**RE: St Aloysius College – Wyalla
Response to Consent Authority Comments**

This letter has been prepared in response to comments, included below, received from the North Shore Historical Society.

2 East Elevation
Scale: 1:200

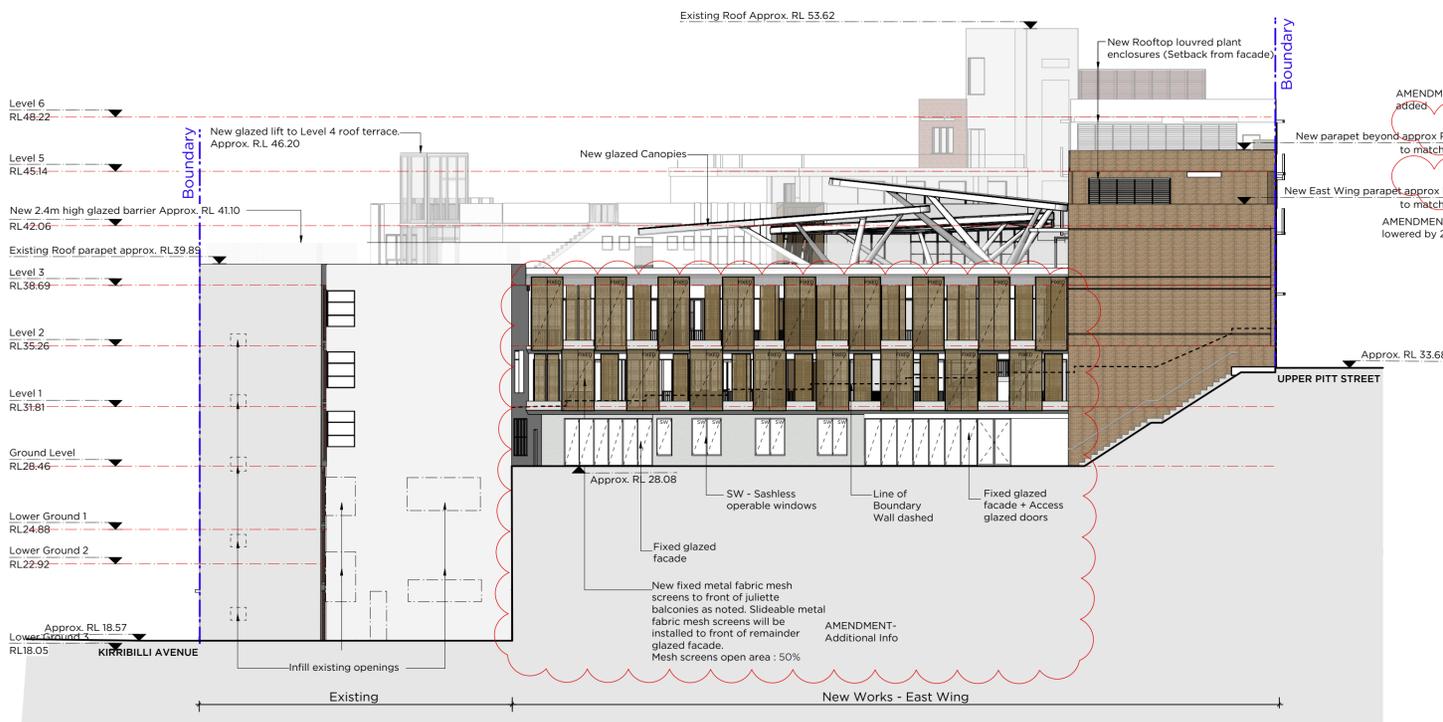
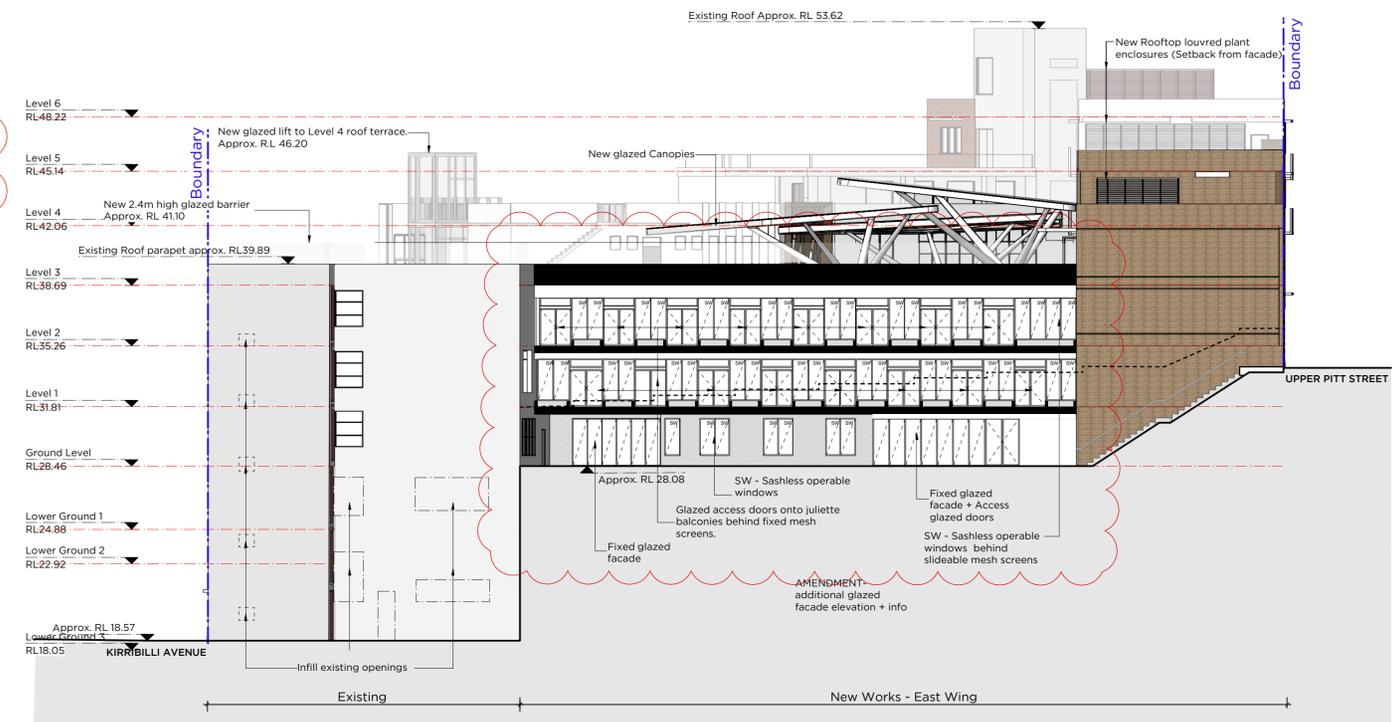
Unsympathetic additions have already been made to the south side of the building. To this point in time, the eastern side of this historic building has remained intact. The removal of wall masonry, and particularly, the removal of the eight double hung timber windows on the ground floor, would destroy the historical integrity of the eastern side of the structure and would diminish the heritage value of the entire building. Any such substantial alterations would be irreversible. The relationship of these ground floor windows to the matching eight windows on the first floor is an integral part of the heritage building.

Regarding comments from the North Shore Historical Society, we acknowledge the proposed works include the removal of windows from the eastern elevation would have an adverse impact on original building fabric. In my earliest site visit the issue of the extent of the demolition to the eastern side of the building was discussed. At that time, we advised there was risk involved in removing the wall (and

associated openings) however the requirement for the additional space resulted in moving forward with the proposal and identifying any mitigating measures that could be made.

1. The rear of the building is not generally visible from the public domain, and as such does not alter the understanding of the early building and particularly the primary elevation and its open corner setting;
2. The opening would be limited to the outer edges of the outermost windows and be limited to the same height as the existing lintel; and
3. The new structure would read as clearly contemporary allowing the overall form of the building and the upper windows to the eastern elevation to be retained.
